WEST SUSSEX COUNTY COUNCIL CONSULTATION

TO:	Arun District Council FAO: Samantha Allen
FROM:	Highways, WSCC
DATE:	21 st August 2018
LOCATION:	Holly Cottage, Yapton Road, Middleton-on-Sea, Bognor Regis, PO22 6DT
SUBJECT:	M/83/18/HH New vehicular access. Additional information received.
RECOMMENDATION:	☒ Advice ☐ Objection ☐ Modification ☐ No Objection ☐ More Information ☐ Refusal
S106 CONTRIBUTION TOTAL:	£N/A

Holly Cottage, Yapton Road, Middleton-on-sea, Bognor Regis

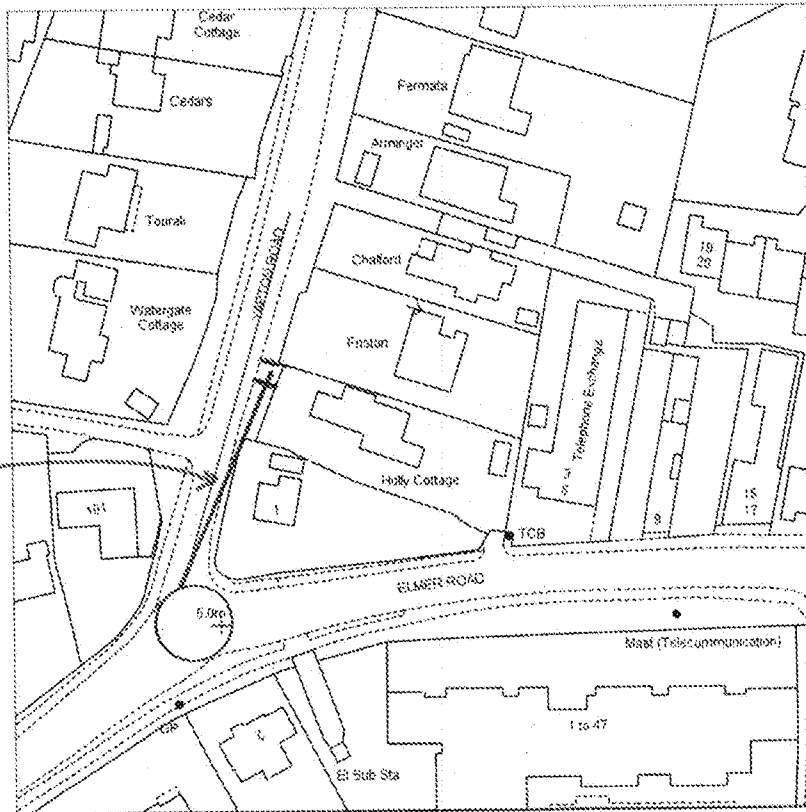
The applicant has provided further information and a plan demonstrating the achievable visibility splays from the proposed access point.

The LHA previously stated that a splay in excess of 2.4m by 43m is achievable to the north within the highway boundary, suitable to the posted speed limit of 30mph. To the south a splay of 2.4m by 38m to the centre line (to the roundabout) has been demonstrated. Manual for Streets 2 paragraph 10.5.5 states that some circumstances, such as opposing flows being physically segregated, make it unlikely that vehicles would be approaching in the left lane, from the left. Whilst there is no physical feature or road markings to deter this in this location, the LHA acknowledge vehicles will have just negotiated the roundabout, the geometry of the road in this location and anticipated speeds lower than the posted limit mean that it is unlikely vehicles would be overtaking. We therefore

consider that the splay taken to the centre line is acceptable to the anticipated speeds. Considering this is achievable entirely within publically maintained highway we would not require a condition to secure these splays though we would advise that any existing concern with overgrown vegetation within the highway verge should be raised with the local area office.
